**Consultation Response from KC,
Lead Local Flood Authority**

2020/91474 Former scrap yard, adj Canalside West, Firth Street, Huddersfield, HD1 3DB

Formation of 55 space car park with associated works

**Date Responded:
19/11/2020**

Area A drains to existing gully

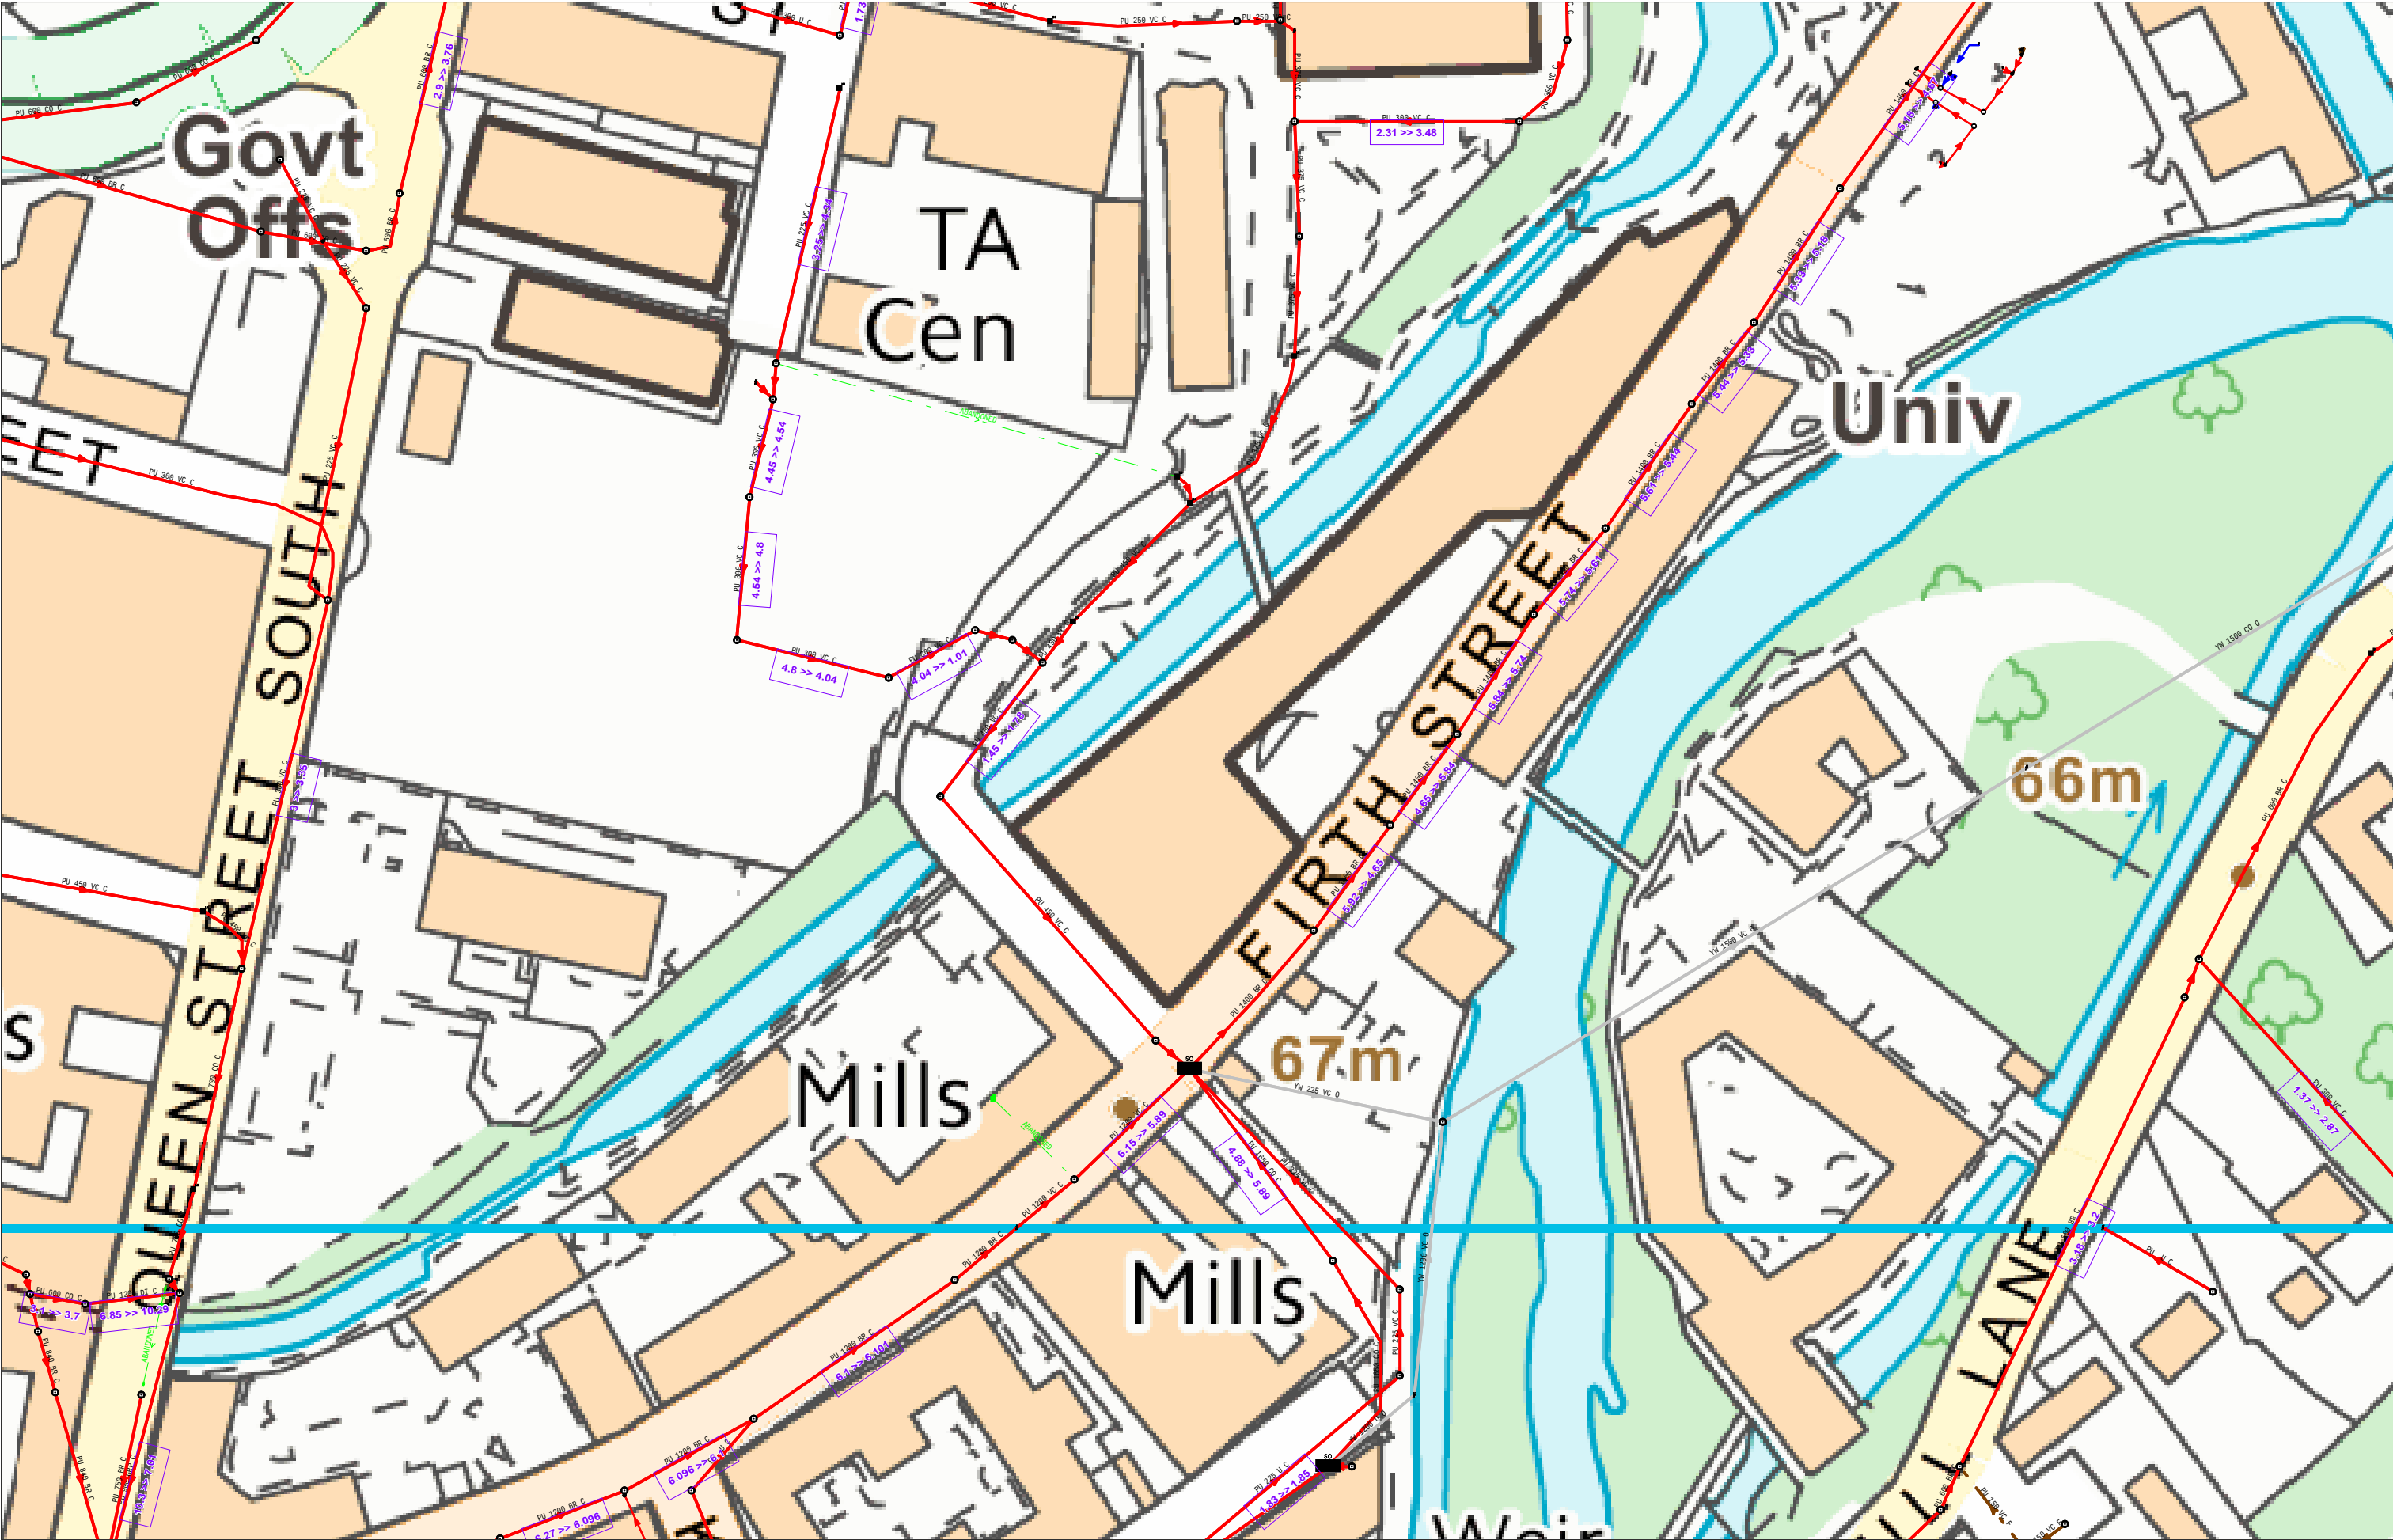
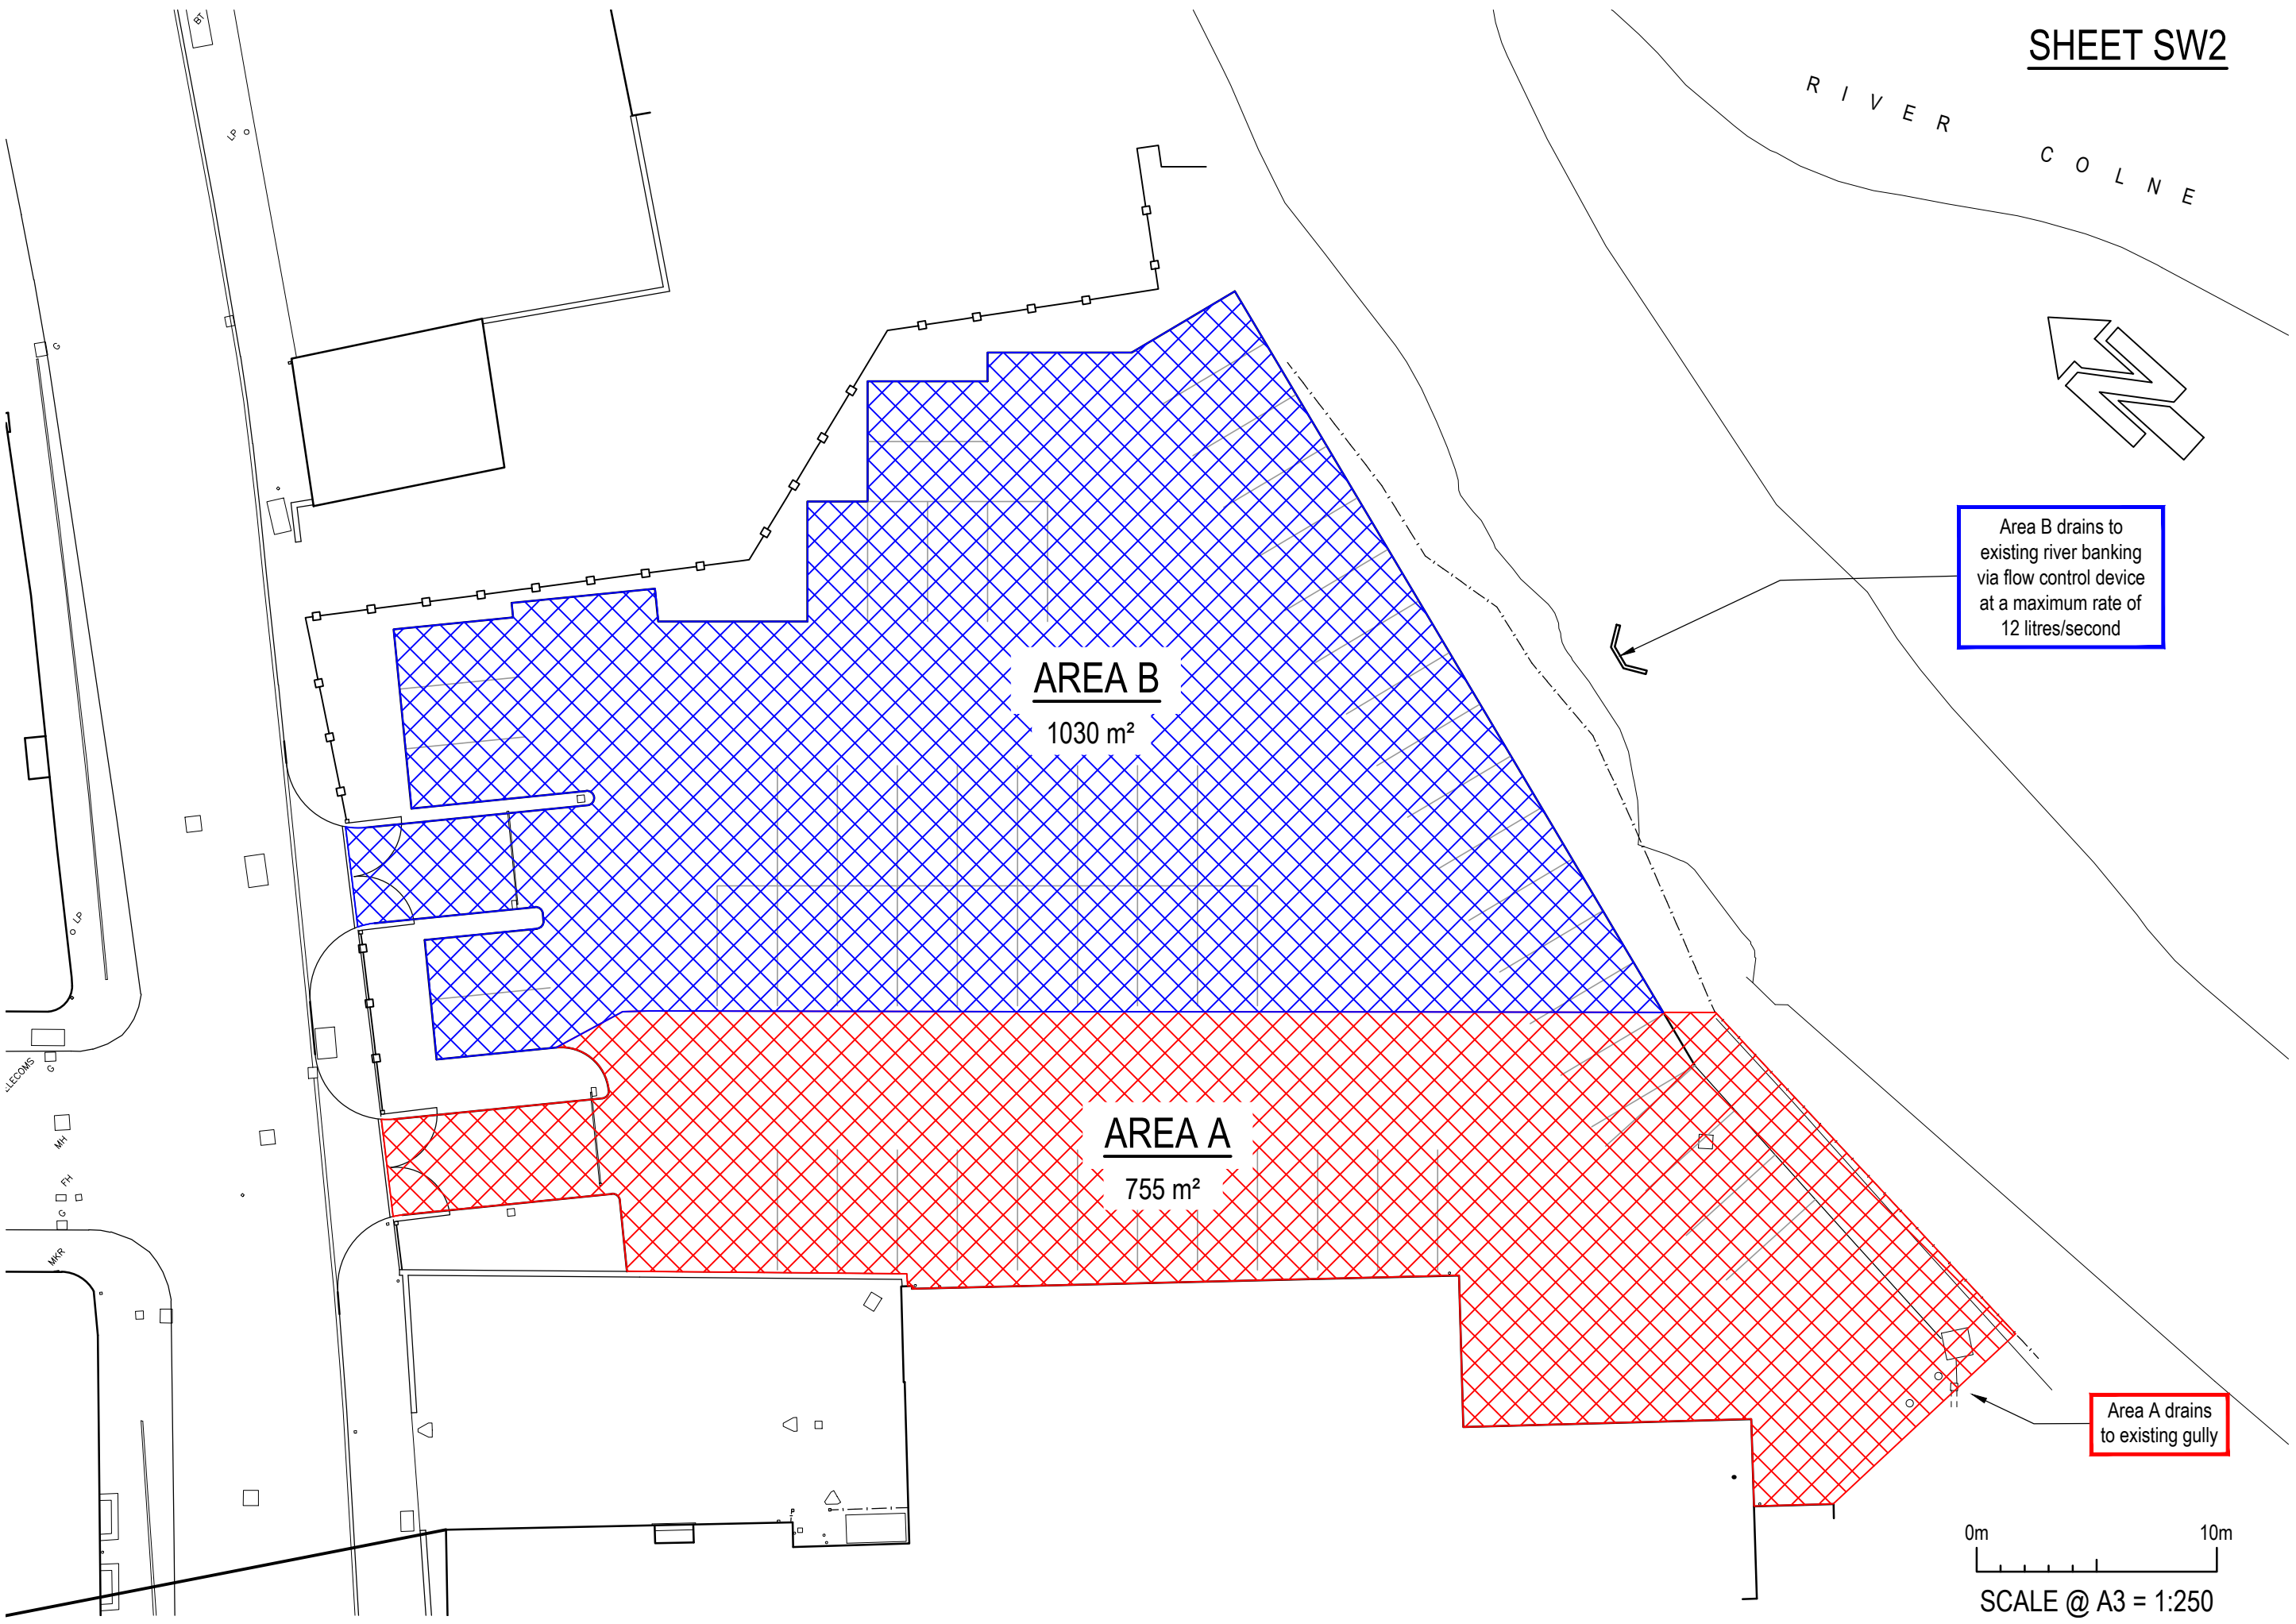
The LLFA **OBJECT** to this application on the grounds that the submitted documents do not comply with the NPPF guidelines on the hierarchy of surface water disposal. However, this objection can be easily overcome by the applicant resubmitting revised drainage statement and drawing showing all surface water drainage from the proposed site discharging to the local watercourse. The rate of discharge should include a 30% reduction on the pre-development discharge rate for the whole area of the site to the watercourse.
